EPC STORMWATER REVIEW COMMENTS
 IN ORANGE BOXES WITH BLACK TEXT

EL PASO COUNTY GRADING AND EROSION CONTROL PLAN CHECKLIST

PPR246

C3.0

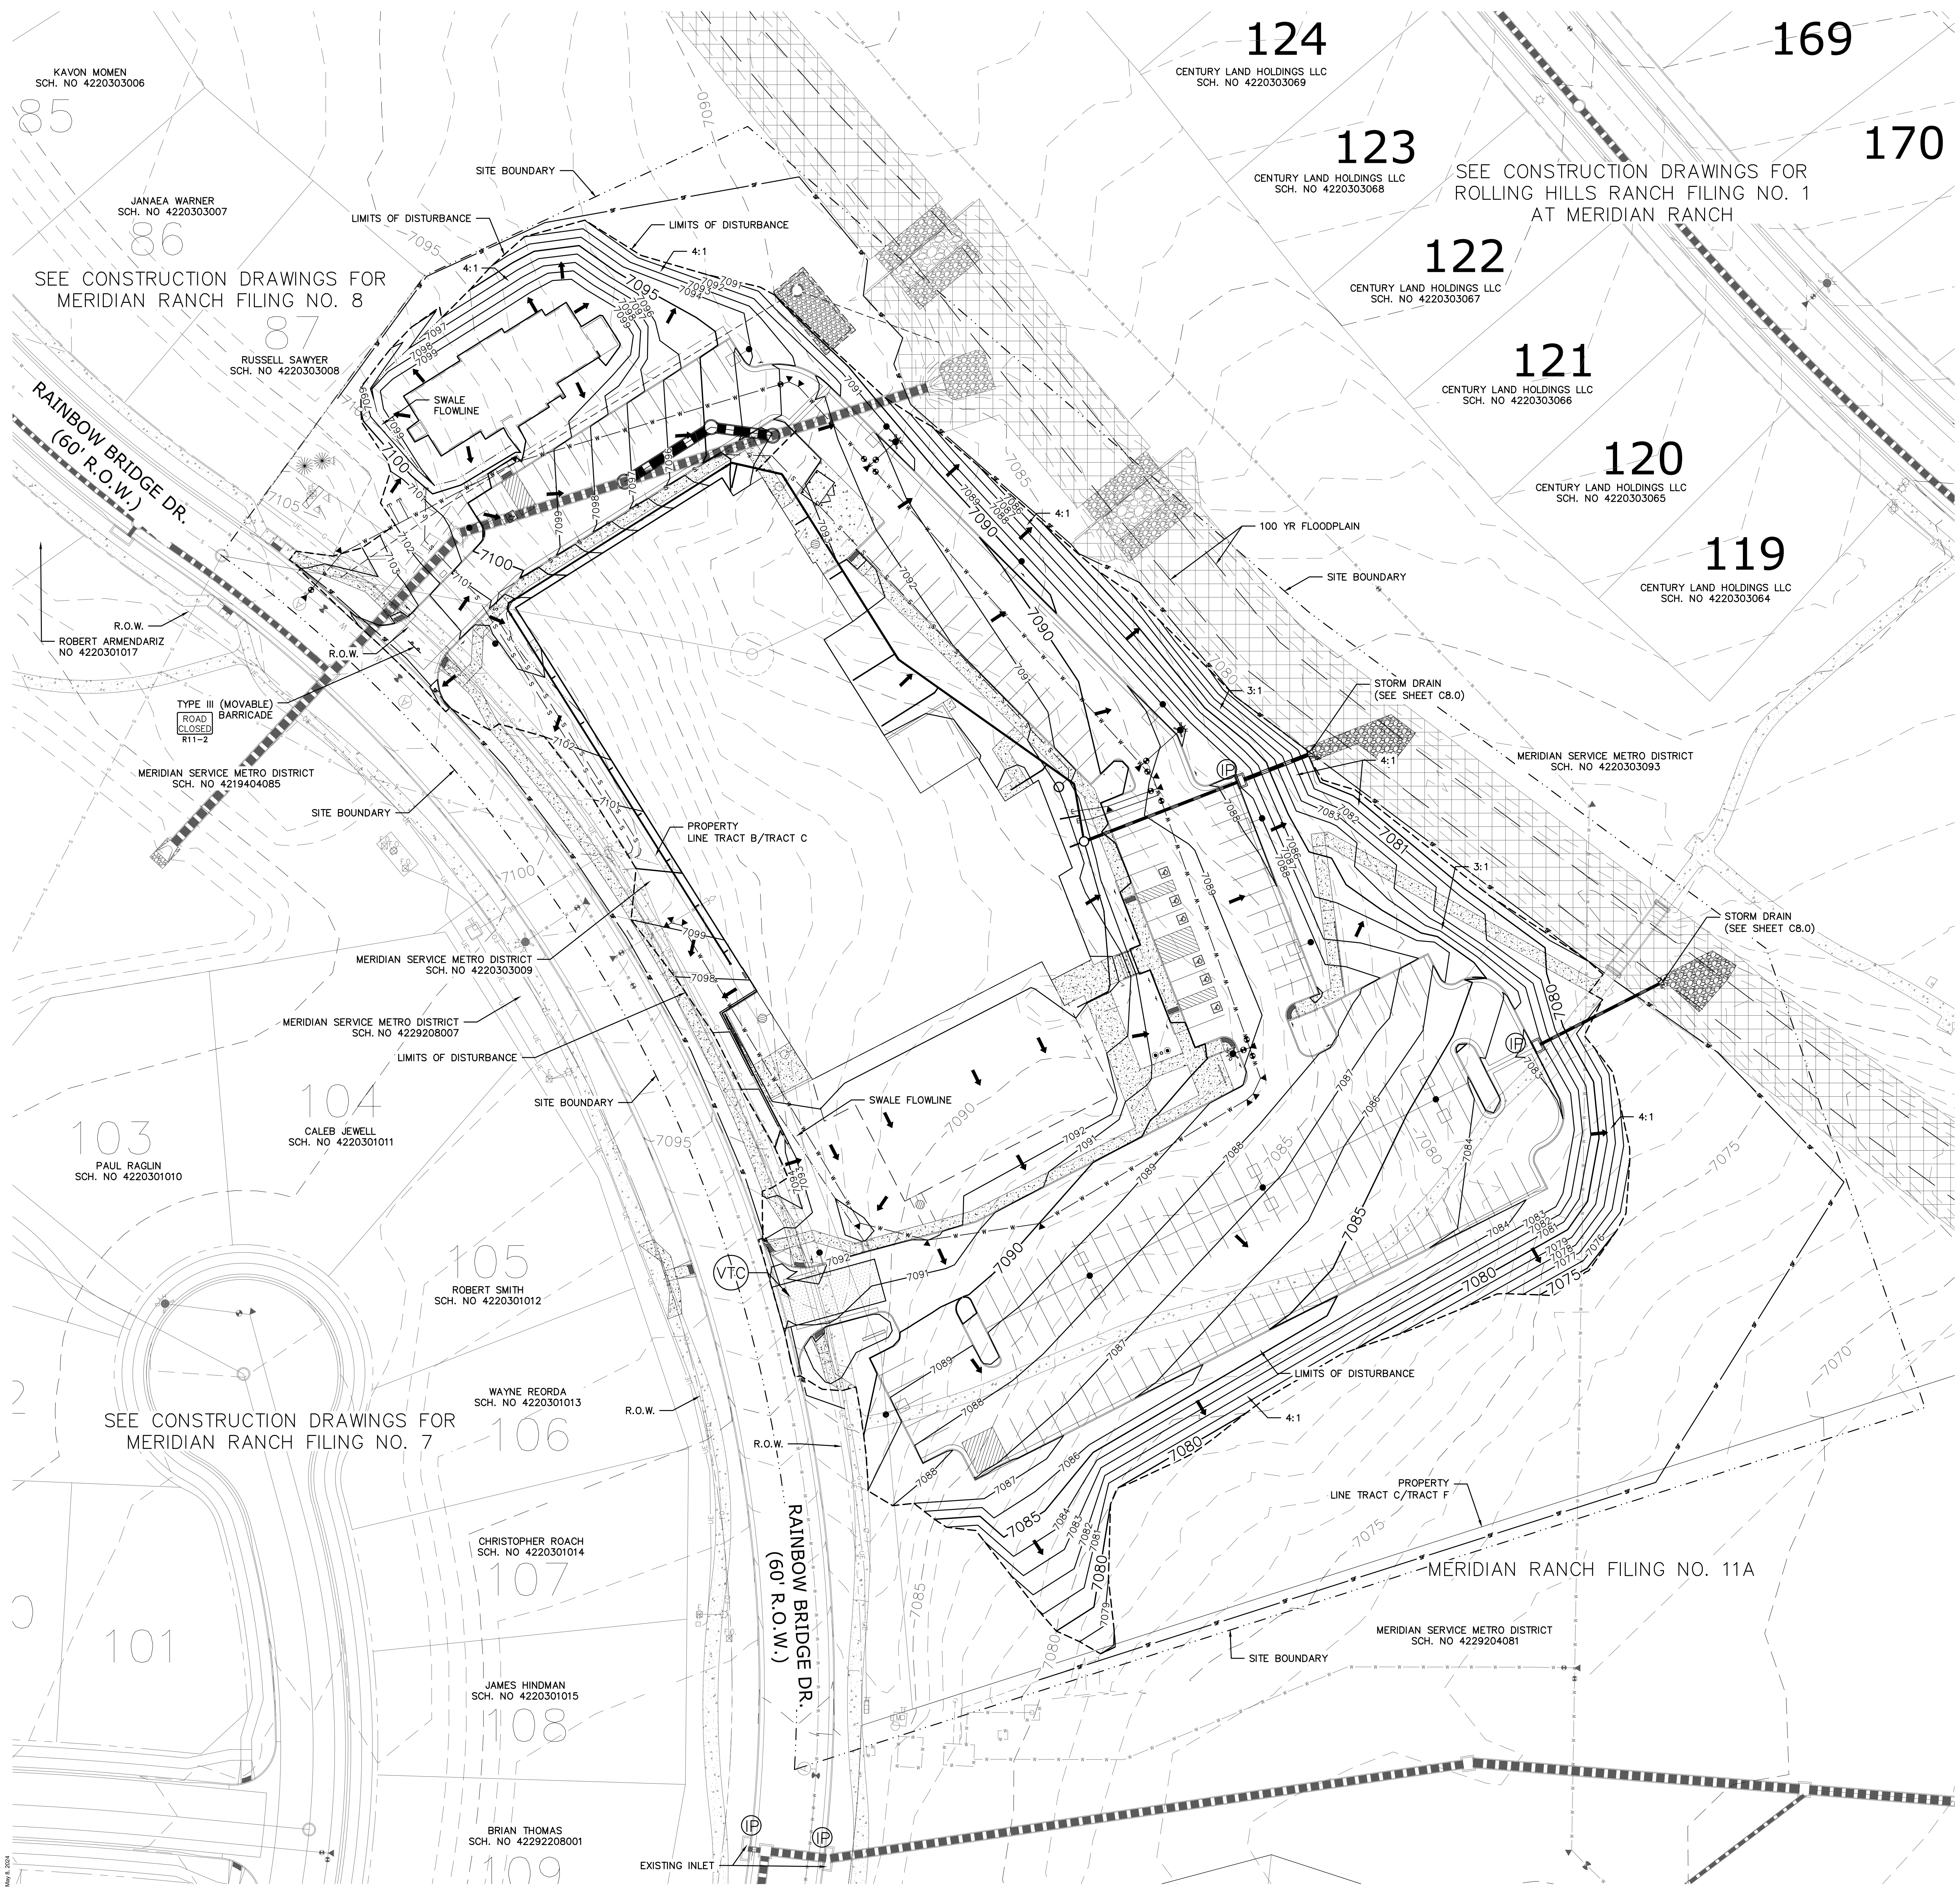
The plans do not show locations of diversion, pumps, discharge location etc. If anticipated provide

Pond D is under the direct ownership of the owner, correct? Wouldn't this be N/A?
